From: Bruce Taunton
Sent: 29 June 2017 09:57
To: Planning.Responses
Subject: RE: Planning Consultation on: Y/33/17/PL

NOTIFICATION FROM ARUN DISTRICT COUNCIL
Town & Country Planning Act 1990 (as amended)
Town and Country Planning (Development Management Procedure) (England) Order 2015
Planning Permission
APPLICATION Y/33/17/PL

Registered: 9th June
2017
Site Address: Stakers Farm North End Road Yapton BN18 0DU
Grid Reference: 497731 103487

Description of Works: 2No. detached dwellings. This application affects the setting of a Listed Building & the Character & Appearance of the Yapton (Main Road) Conservation Area.

*View on east face of eastern boundary wall*

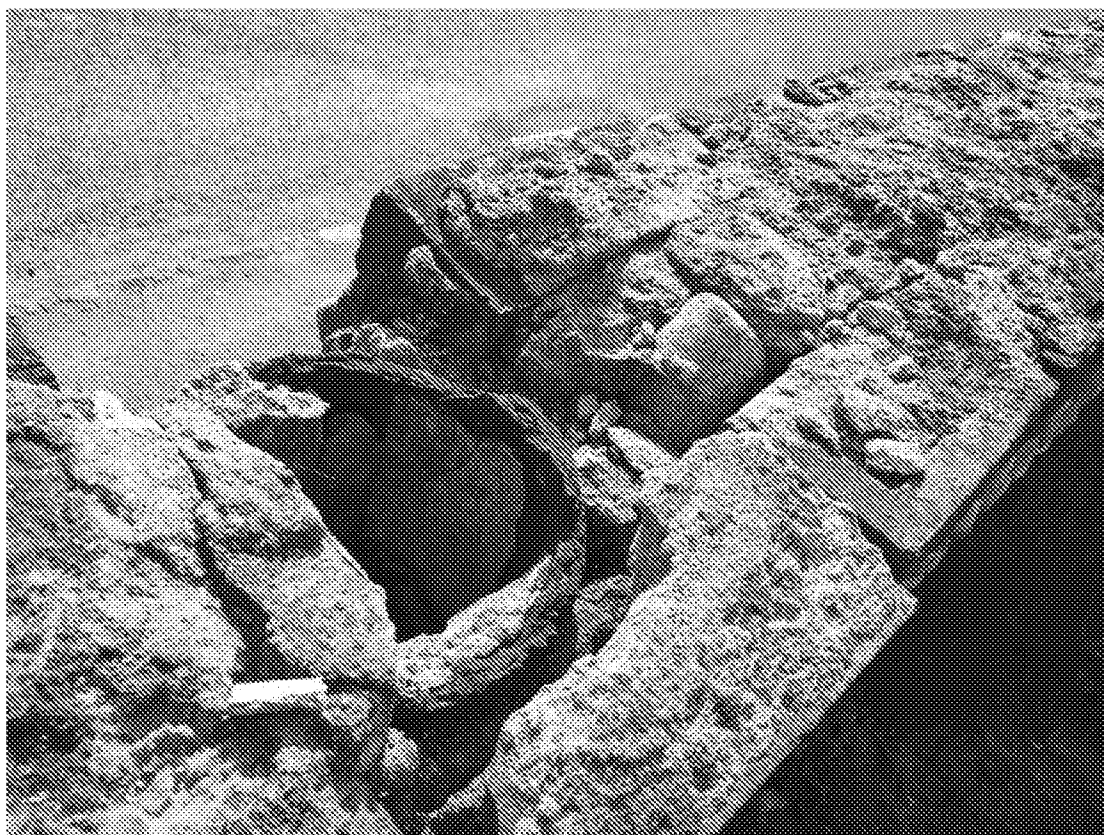
I have no comments of a structural nature as this is mostly new build and is covered by the Building Regulations. The existing boundary wall is of concern as it was clearly not constructed originally to act as both a boundary and retaining wall and is on the main footpath to the school. The wall is leaning over towards the footpath and requires regular monitoring and maintenance to prevent potential failure, especially any falling material from height.
